## Re: Planning Application No: 3/2023/0664

Proposal: Construction of two dugout shelter buildings to replace the existing temporary shelters. Location: Langho Sports and Social Club, Dewhurst Road Langho BB6 8AF

**1\* Proposed Ground Floor Level Plan**  
1:20

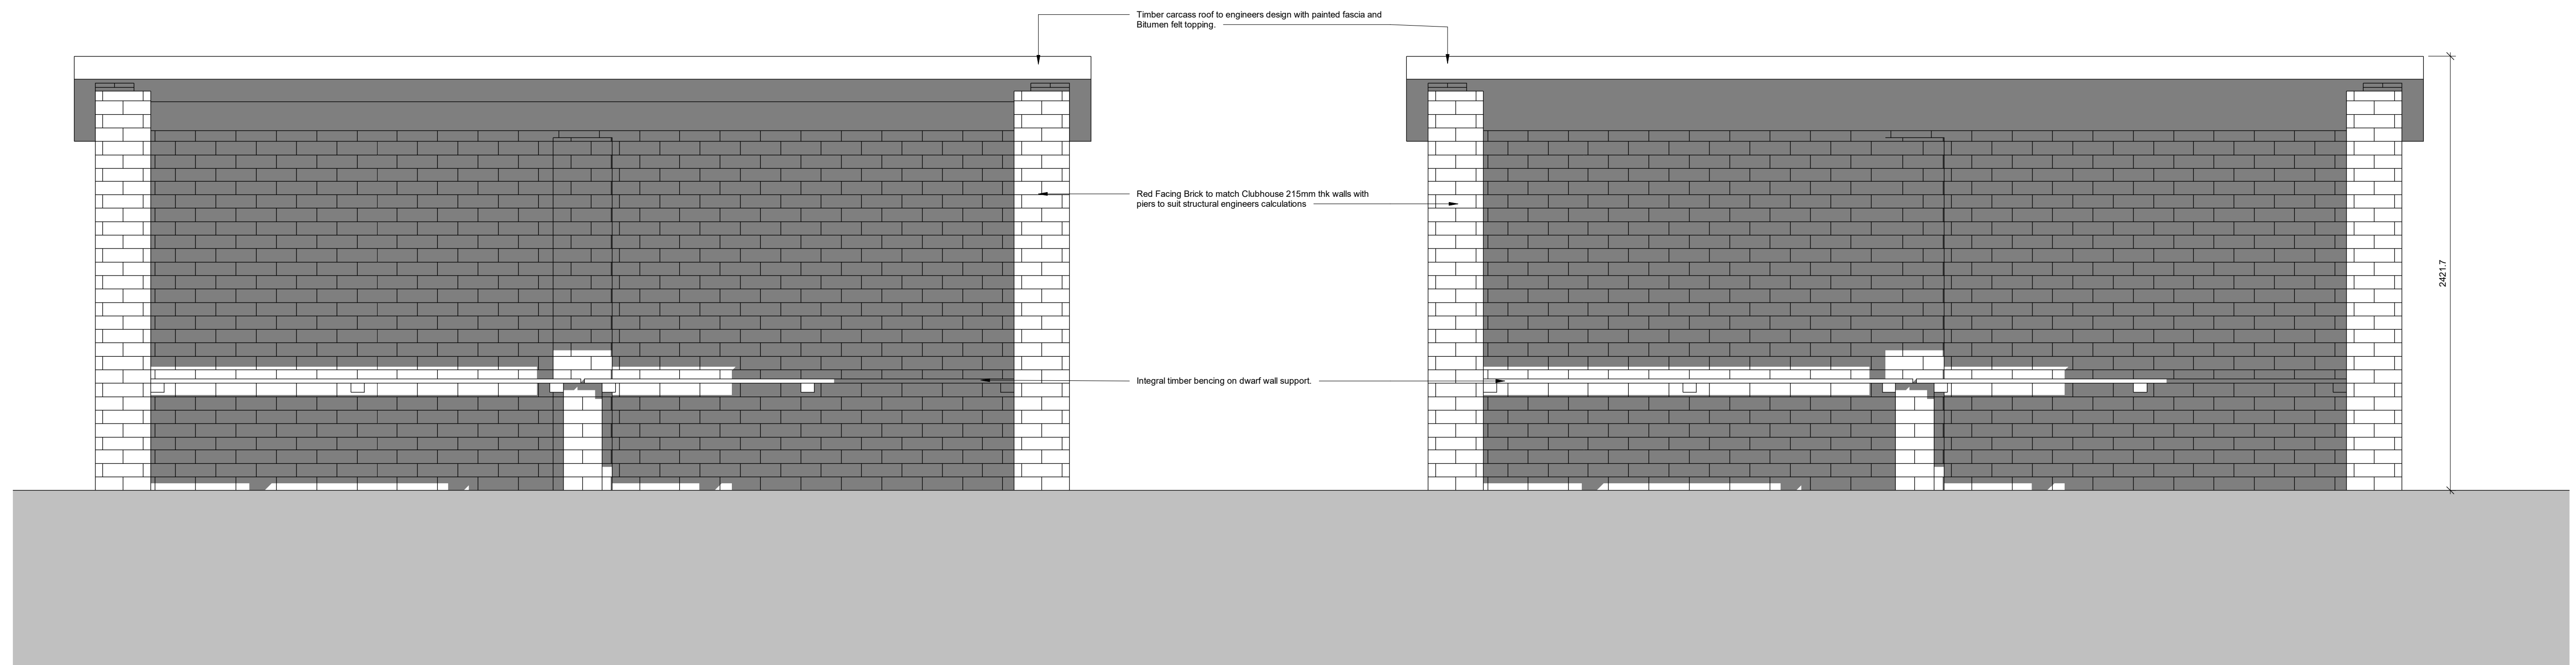
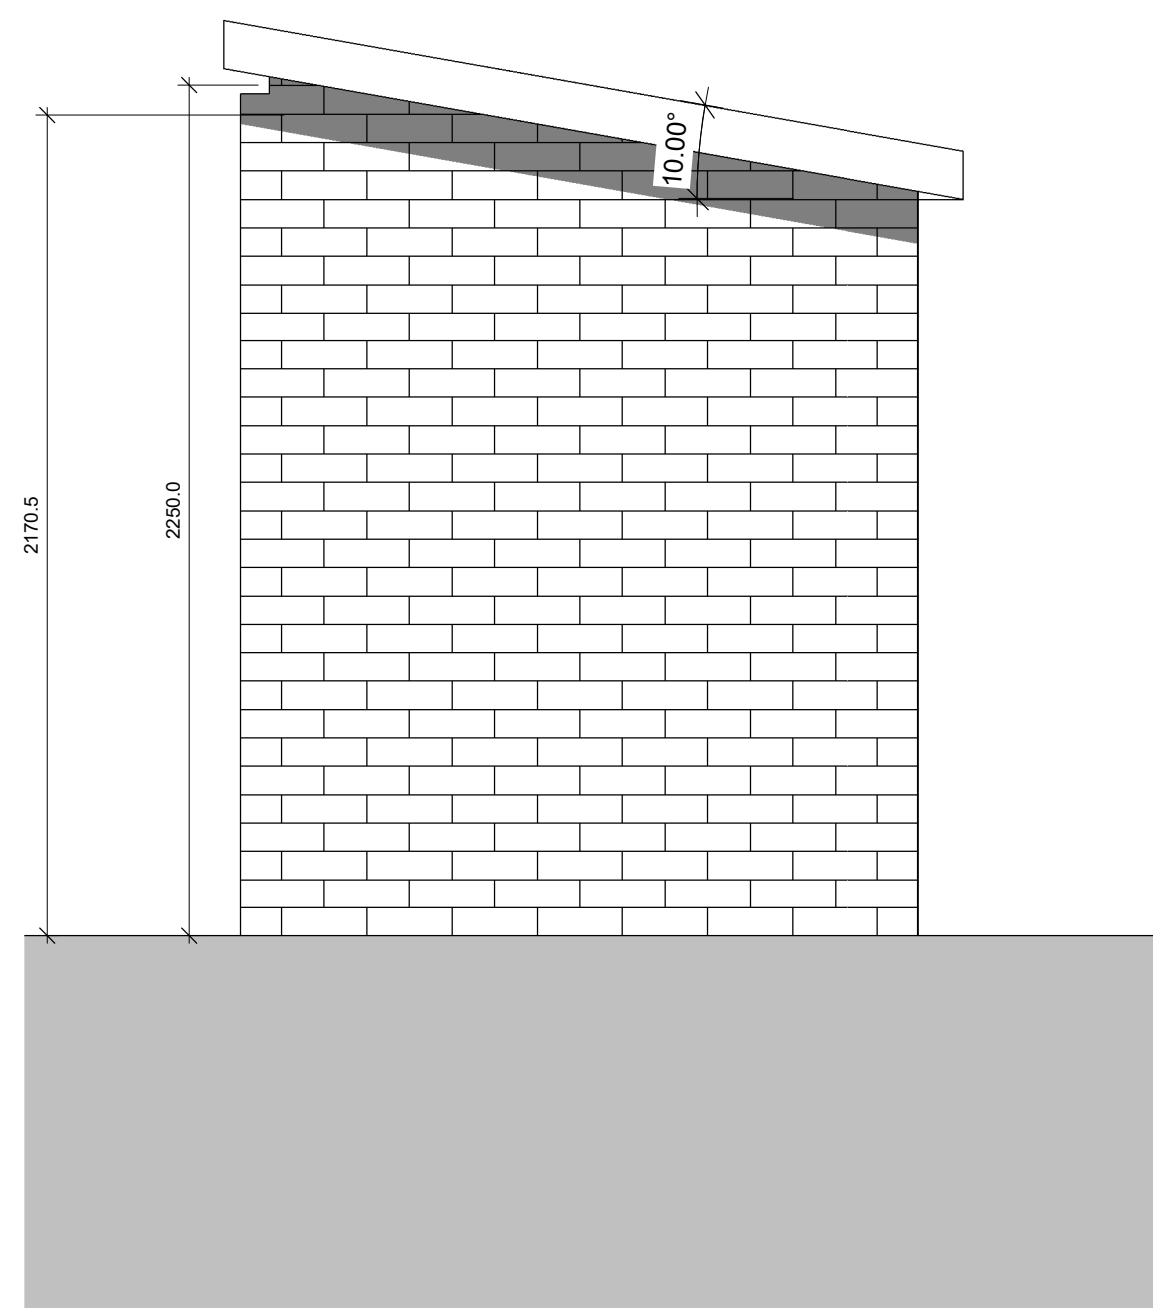
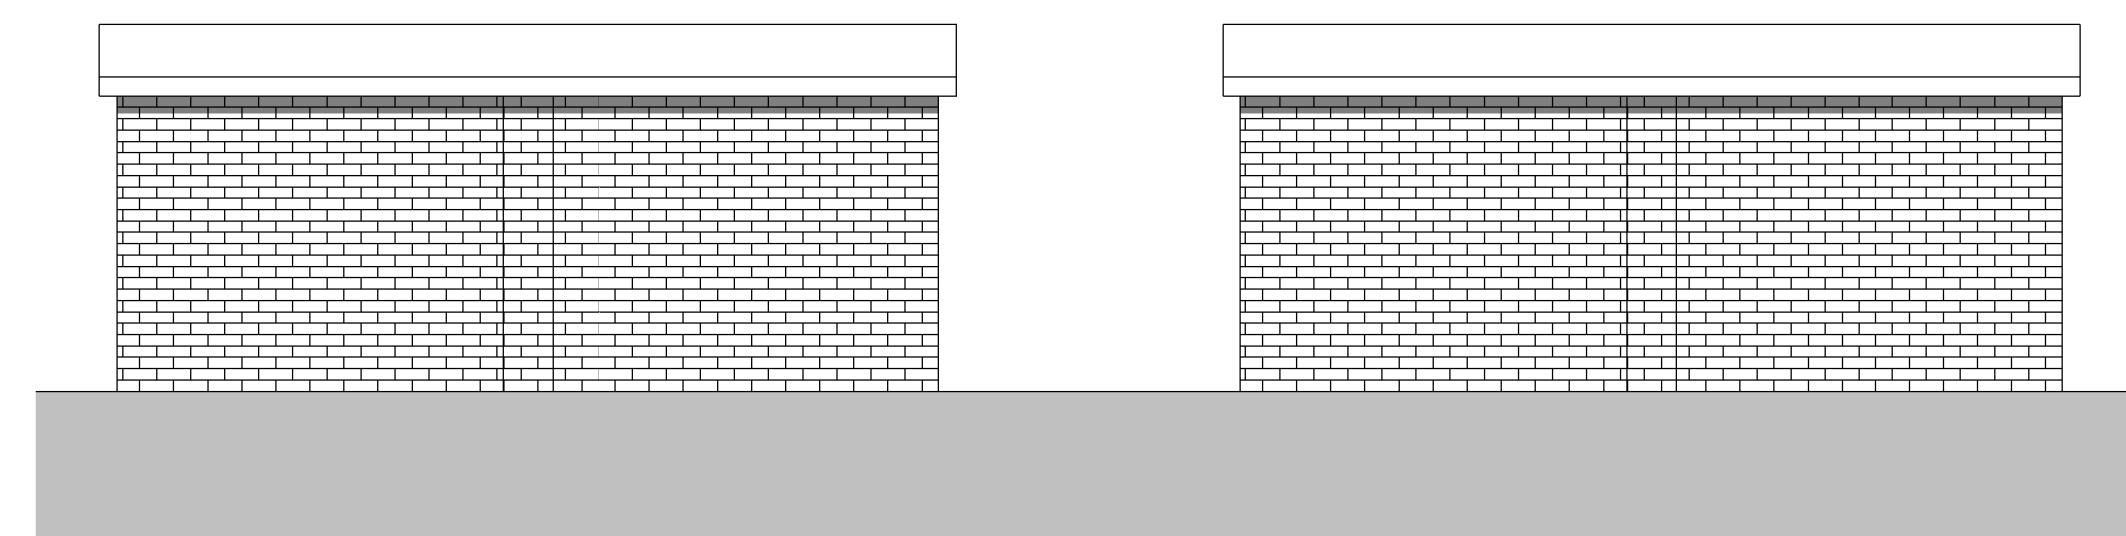
The size and scale of the proposed dugouts and the fact that they are of a permanent construction seems excessive in all respects for the needs of a local sports club.

The dimensions and construction of the proposed dugouts are more akin to two grandstands and greatly exceed the existing provision. These excessively large and permanent brick constructions would be detrimental to the appearance and future flexible use of this community recreational area, and would doubtless lead to, and encourage, further antisocial behaviour and littering of the surrounding area, particularly when not in use by the club.

The dugouts will be overbearing and are not essential. There are currently 2 smaller dugouts already in place. The newly proposed dugouts would not keep the feel of the neighbourhood. They are excessively large or out-of-character with the green space on which they plan to build on.

Langho FC The Rydings proposed site plan

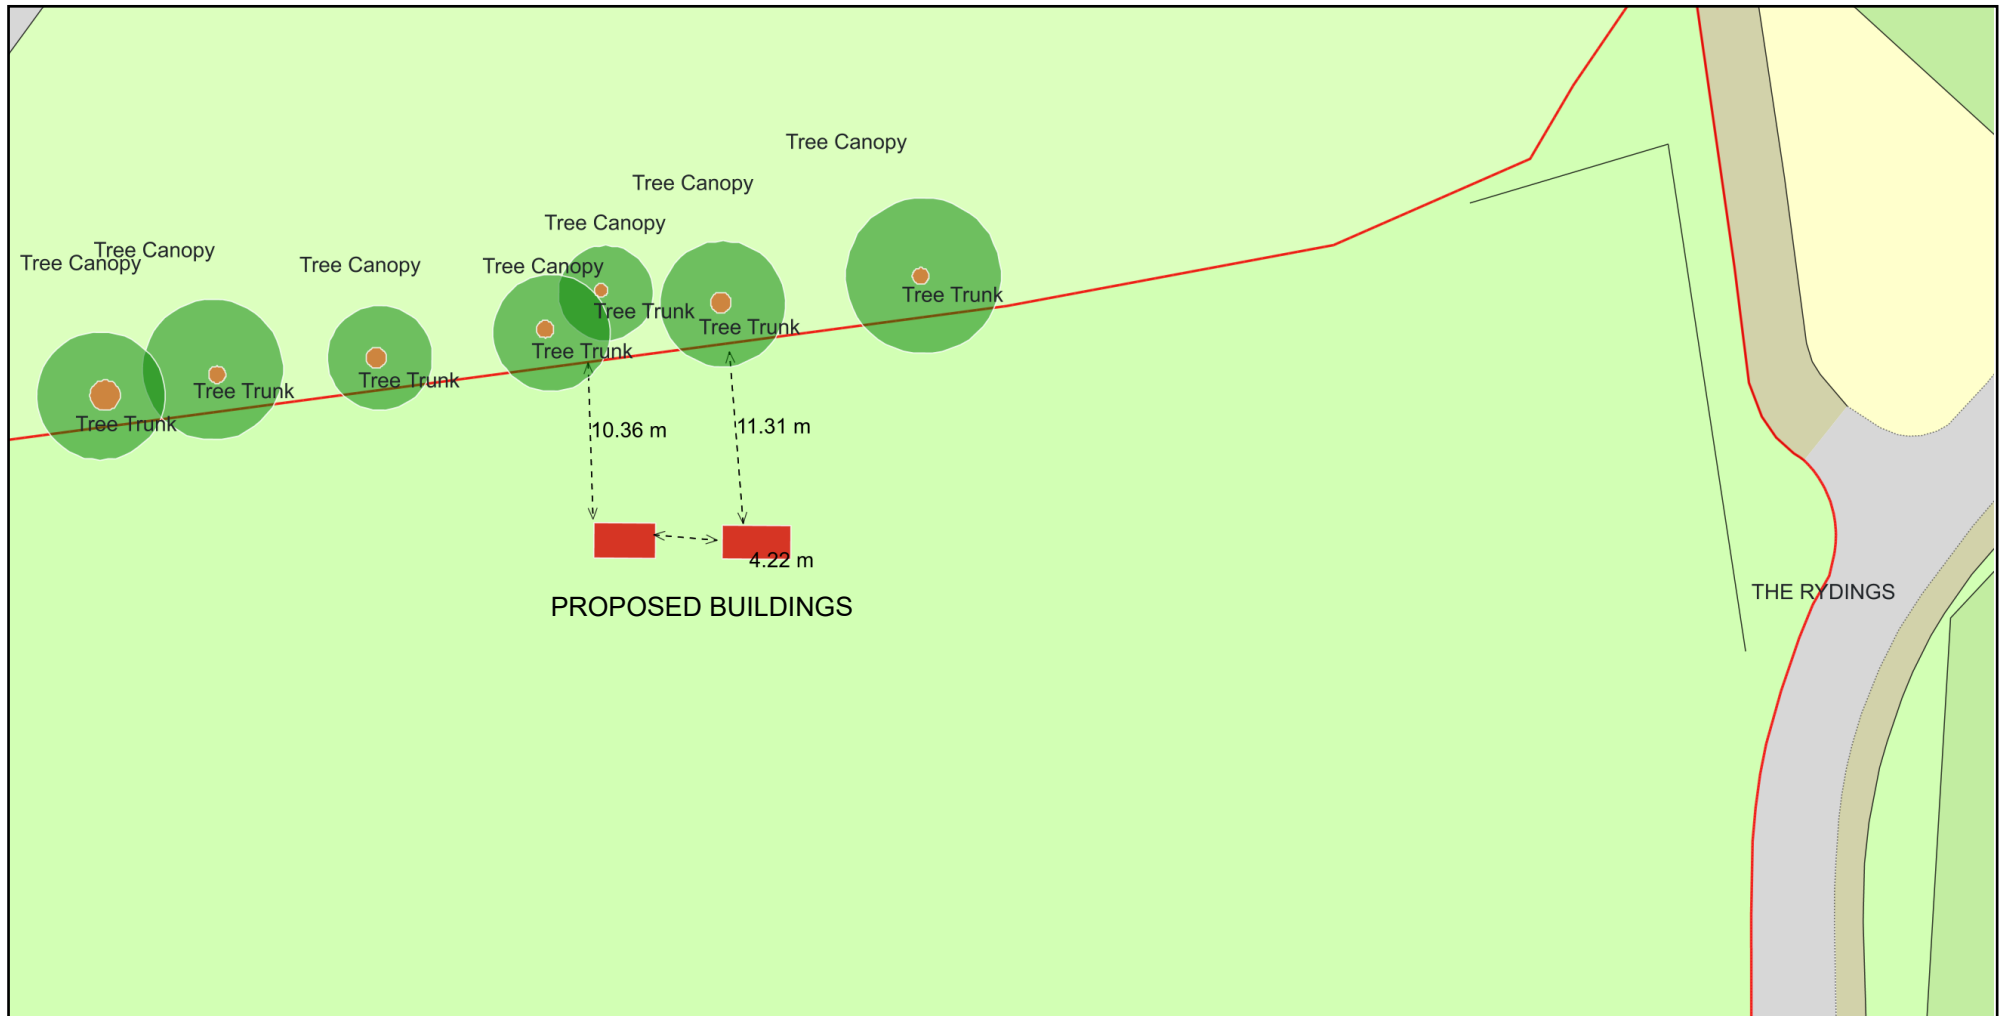
These large imposing structures would not only remove a significant amount of this open area, but also limit the future flexibility of use for different recreational activities.
